**WEST SUSSEX COUNTY COUNCIL
PLANNING SERVICES CONSULTATION**

SUBJECT: A/184/17/PL - Change of use from light industrial (B1 Business) to commercial gym (D2 Assembly & Leisure). This application may affect the character & appearance of the Angmering Conservation Area.

Seymour & Lisle Ltd, The Square, Angmering, Littlehampton, West Sussex, BN16 4EA

Drawings
PROPOSED DRAWINGS:
Site Plan + Floor Plan

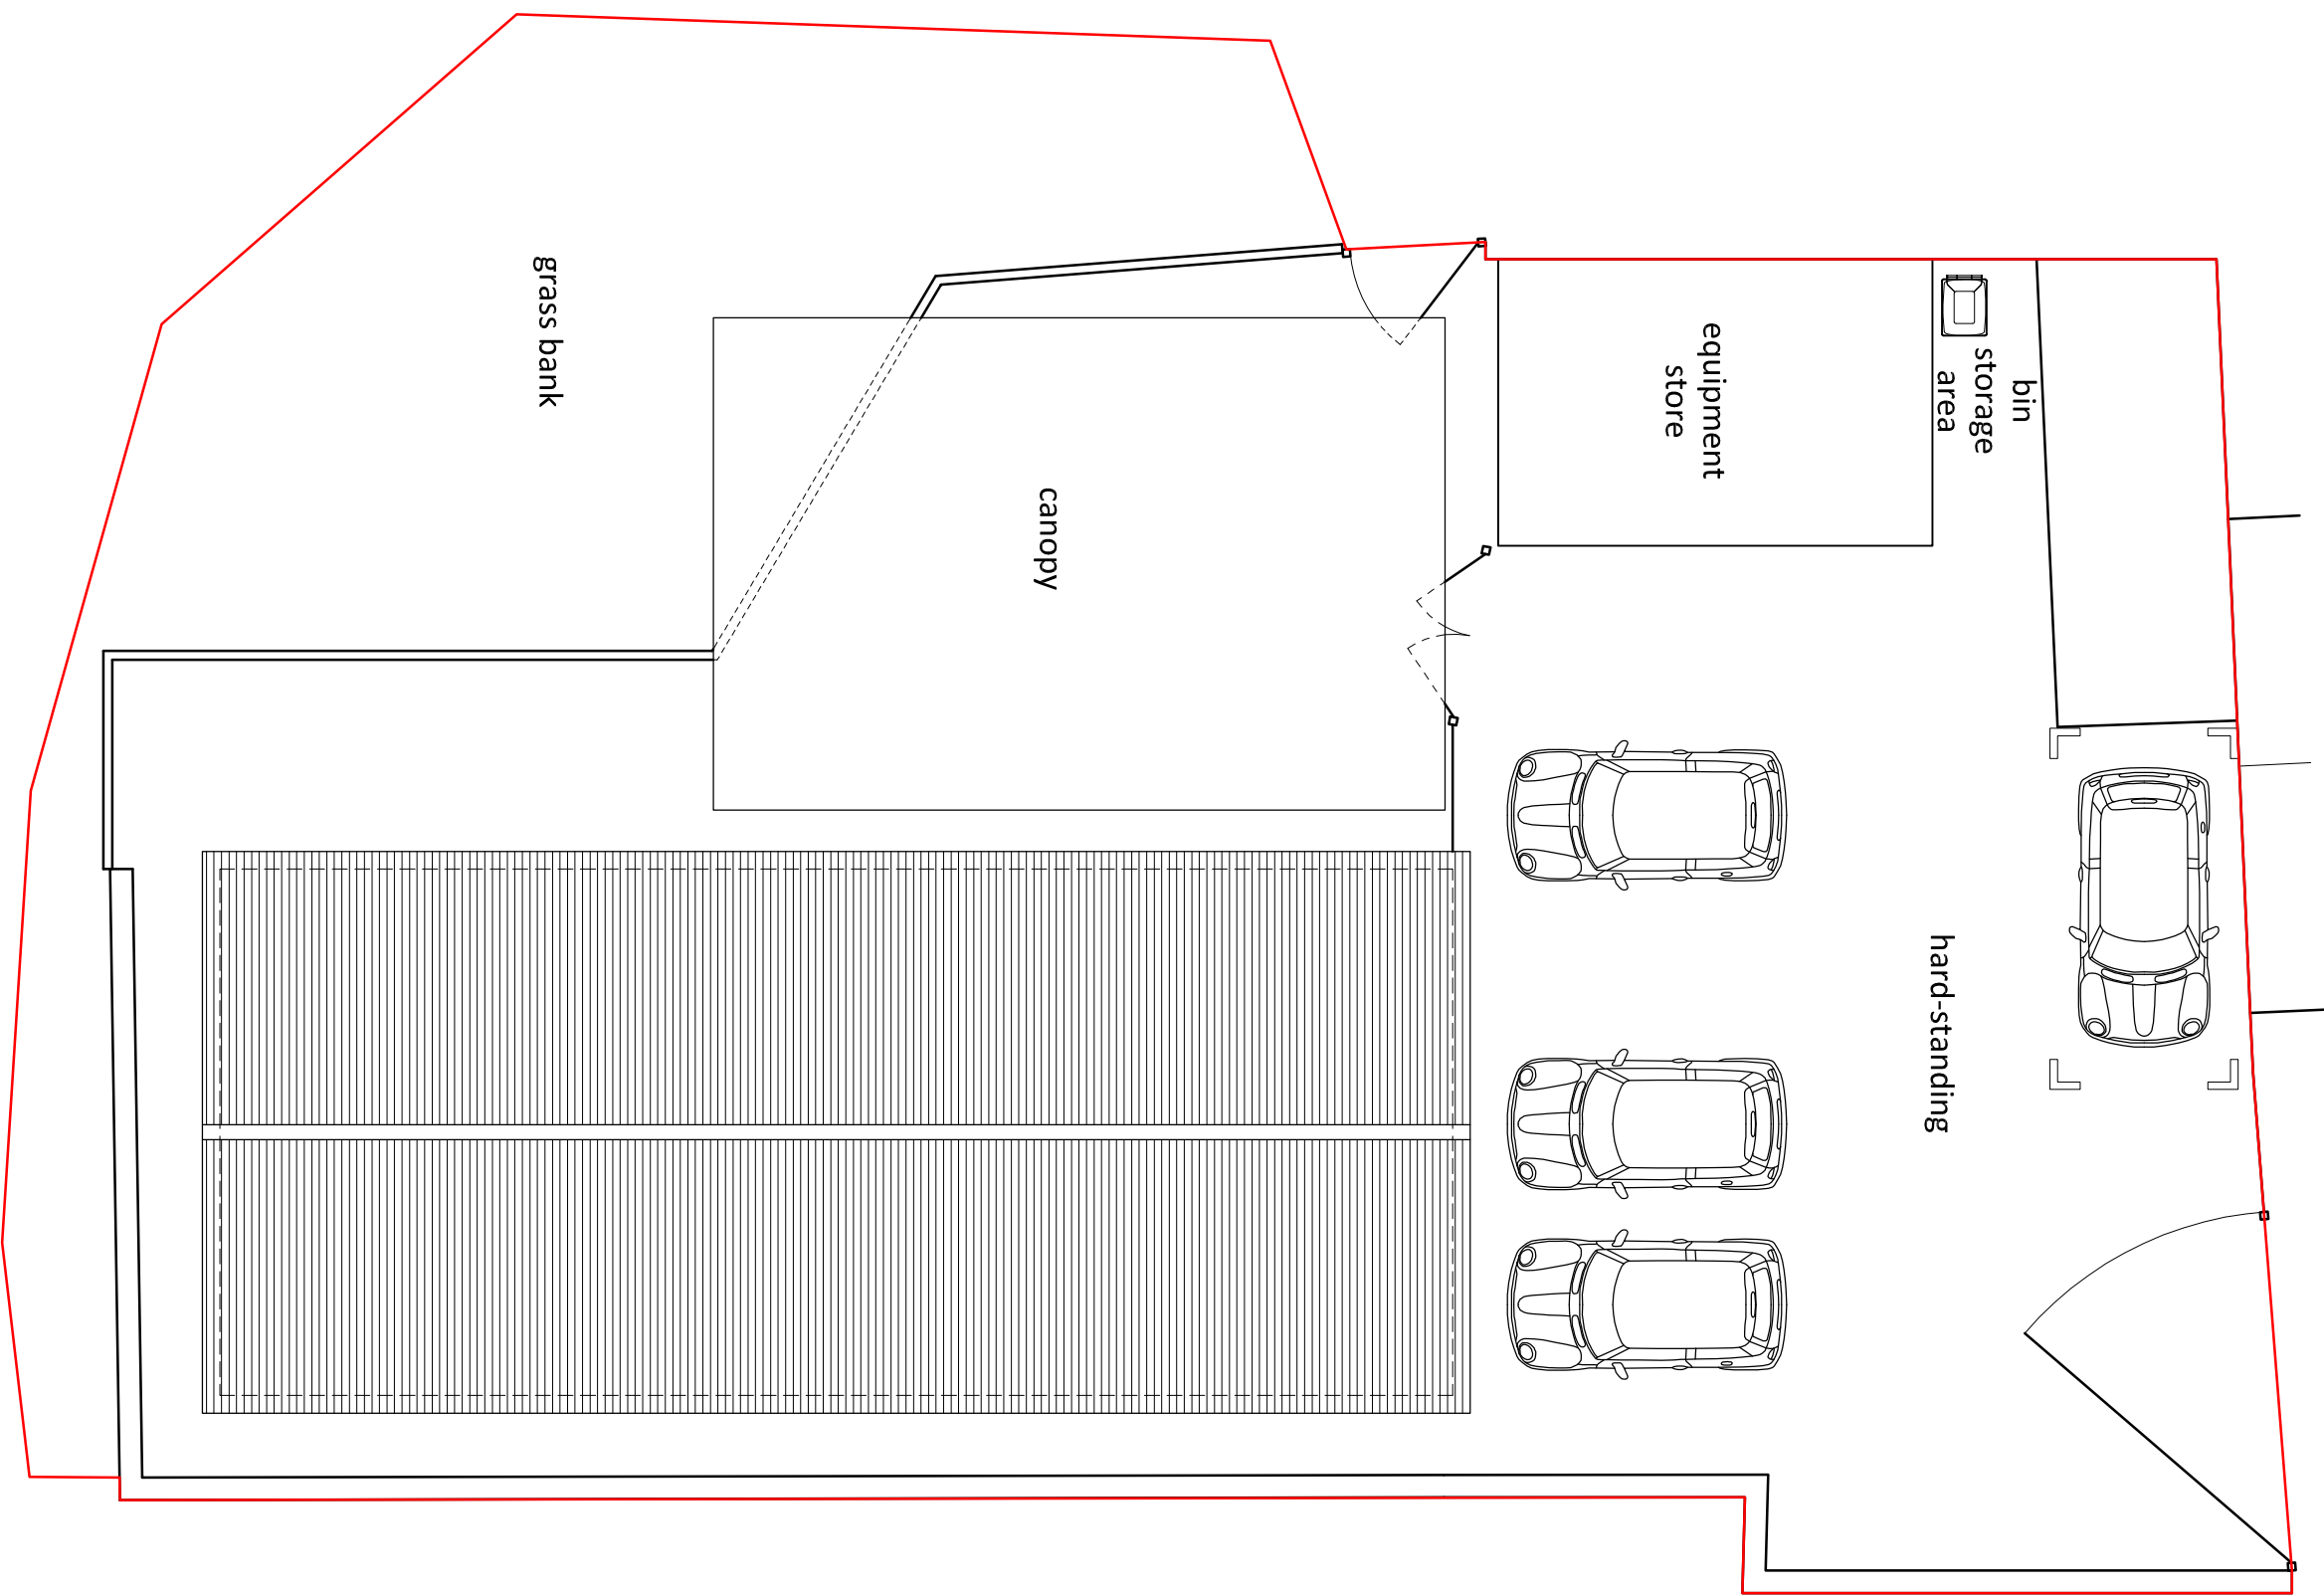
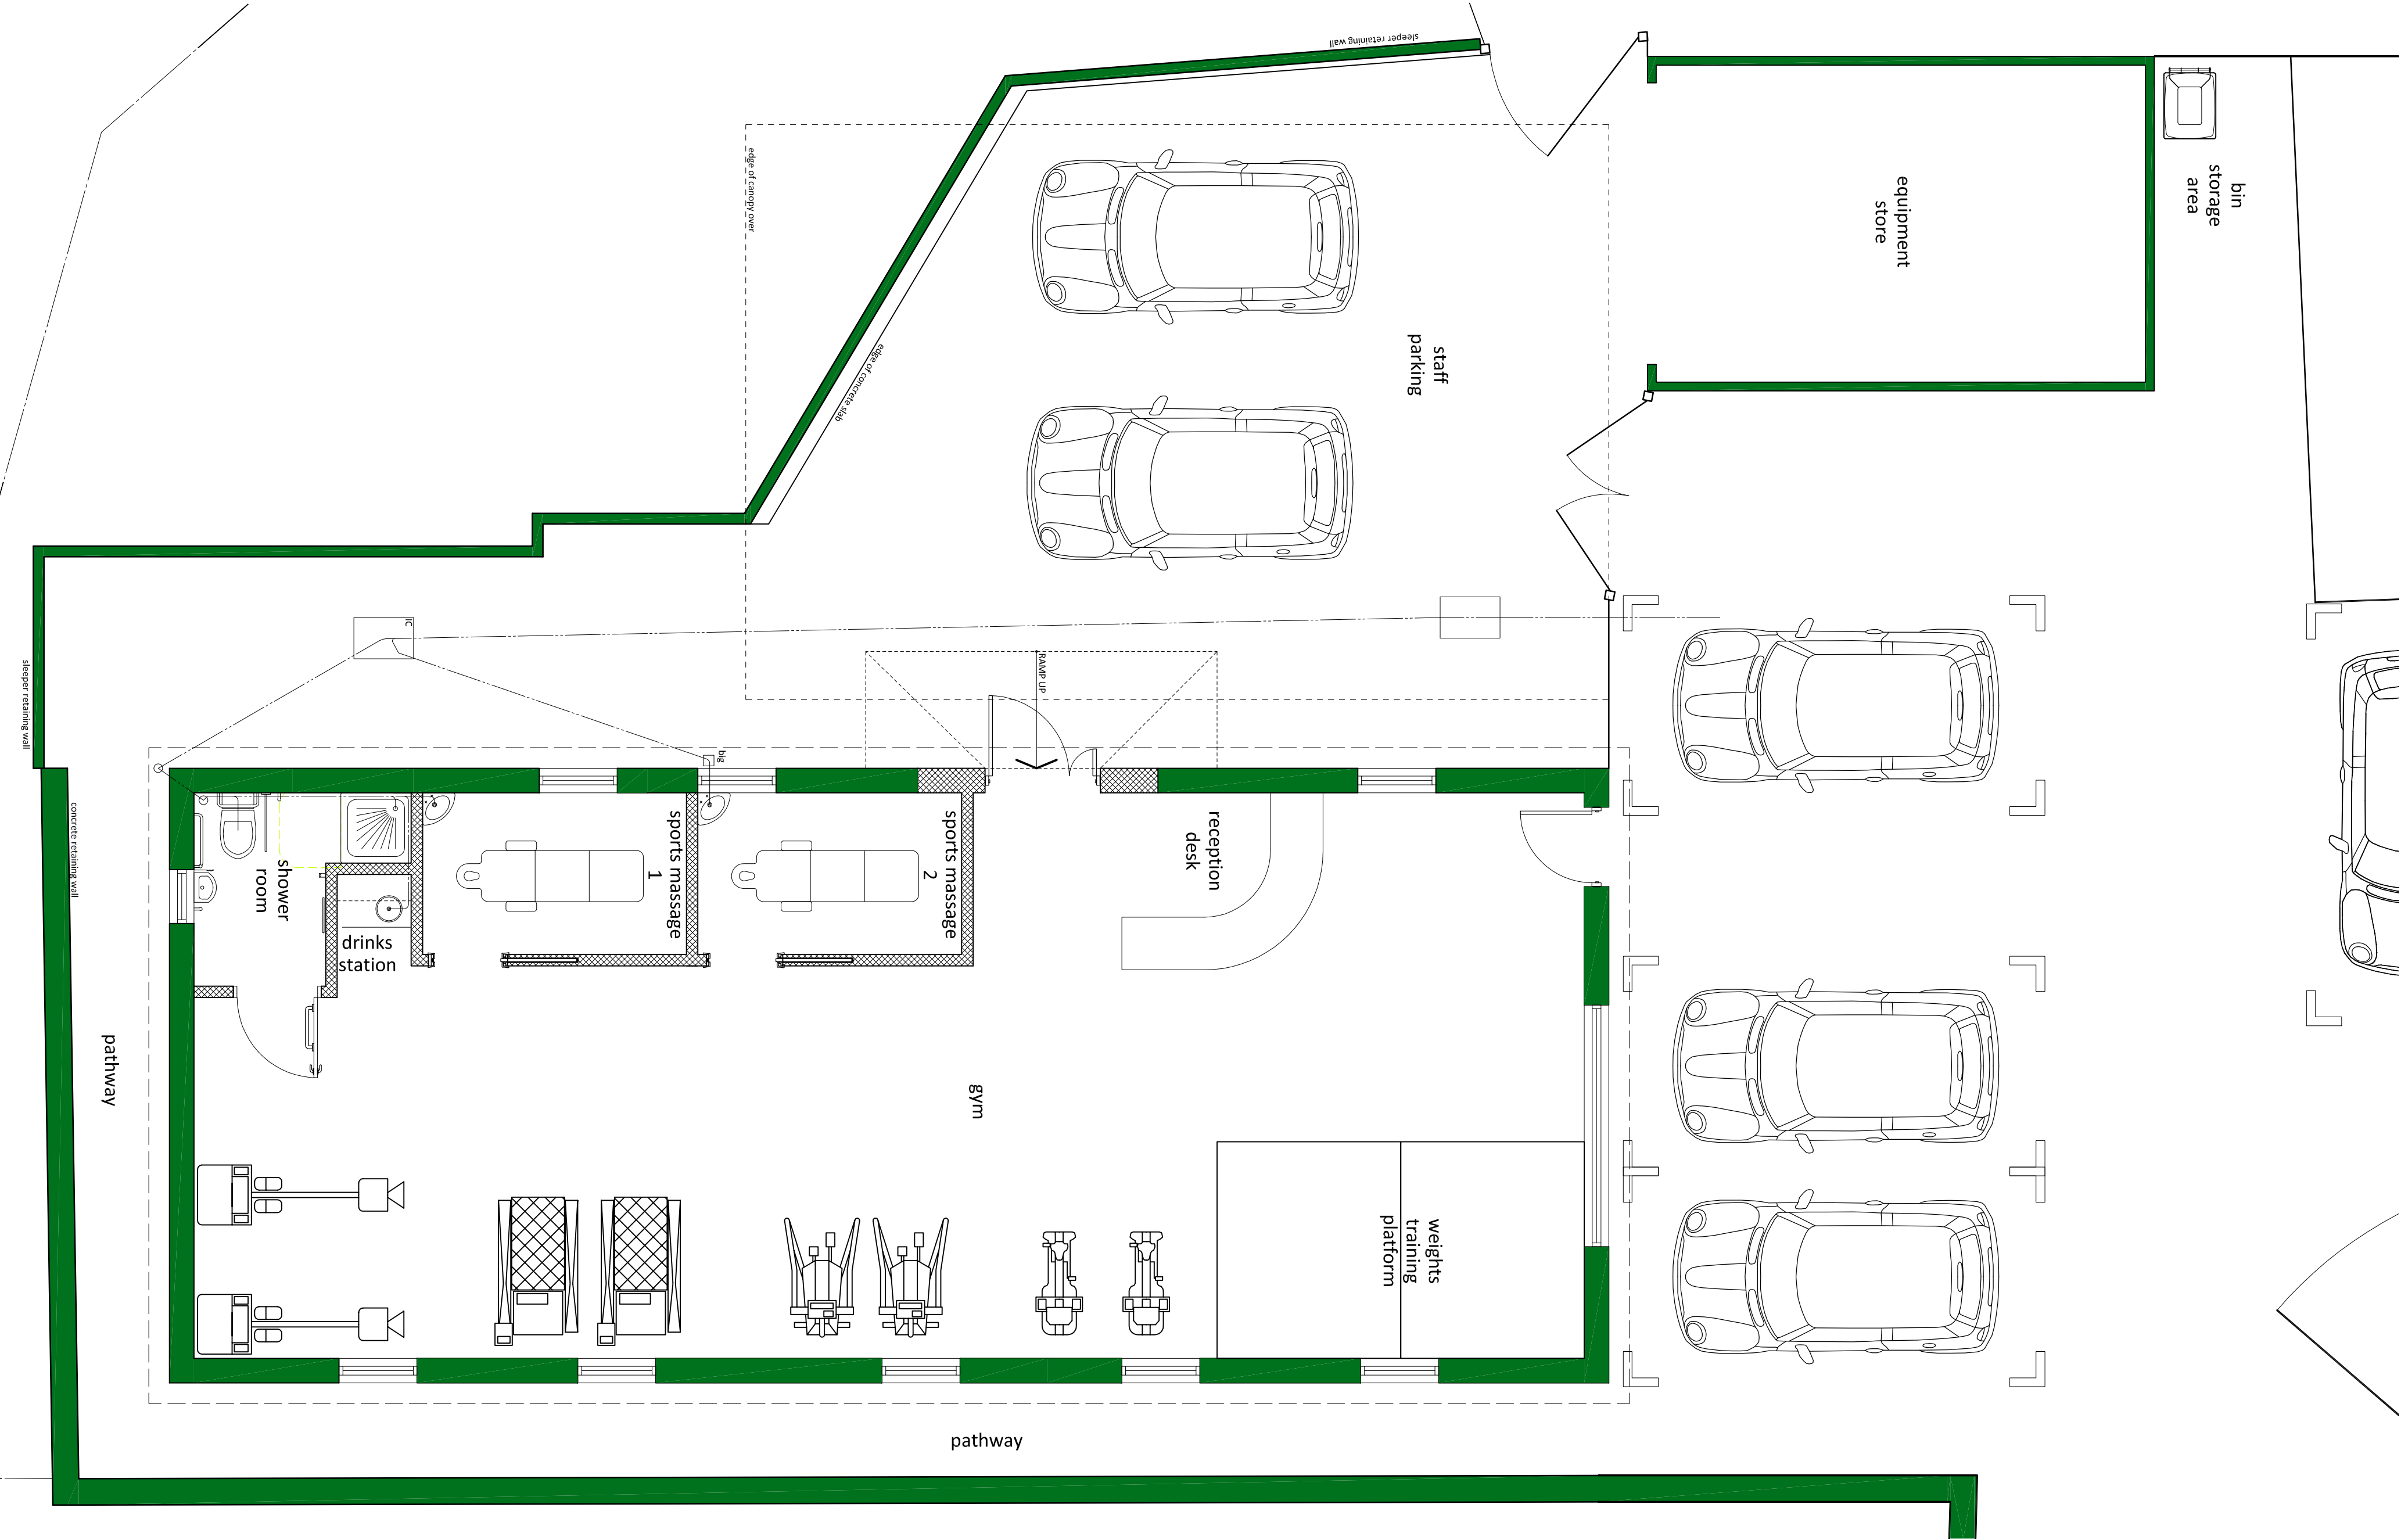
Under the B1C use 5.4 spaces could be provided as a maximum standard. Under the proposed D2 use up to 7.4 spaces could be provided. These are maximum parking standards adopted by WSCC in November 2003. Seven spaces will be provided though two of these are staff spaces within the garage. The layout of these spaces appears restrictive with regard to manoeuvring within the site. The applicant may wish to consider the practicality of this layout regard to space available rear of each space for manoeuvring. Nevertheless, the LHA do not consider that the proposal would result in a car reversing to the highway from this location nor significantly alter the arrangements over the existing situation, which has been operating without evidence of highway safety concern.

If the LPA are minded to approve the application we would advise a condition securing cycle parking.

No part of the development shall be first occupied until covered and secure cycle parking spaces have been provided in accordance with plans and details submitted to and approved by the Local Planning Authority.
